# CITY OF ALBUQUERQUE

**Re: Tam Le Salon  
130 Coors Blvd NW  
Grading and Drainage  
Engineers Stamp Date 8/10/2015 (K10D047)**

Based upon the information provided in your submittal received 8/11/2015, the above referenced Grading and Drainage Plan cannot be approved for Grading Permit or Building Permit until the following comments are addressed.

## GRADING & DRAINAGE PLAN

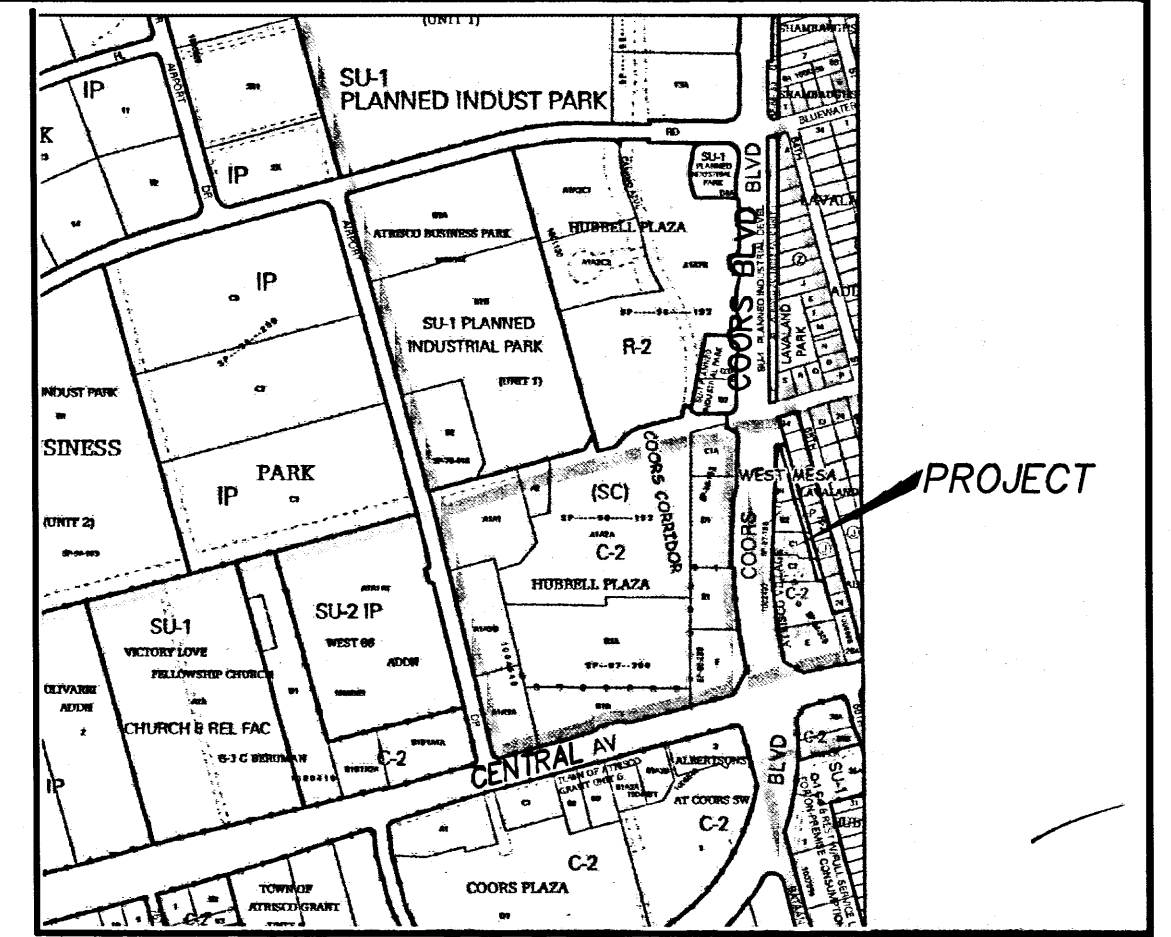
- Provide roof flows.
- Provide flow calculations for the concrete drainage rundown.
- Verify if the system in the sidewalk is a sidewalk culvert or pvc? Provide calculations for either one.
- An access agreement must be provided from the owners to the south.
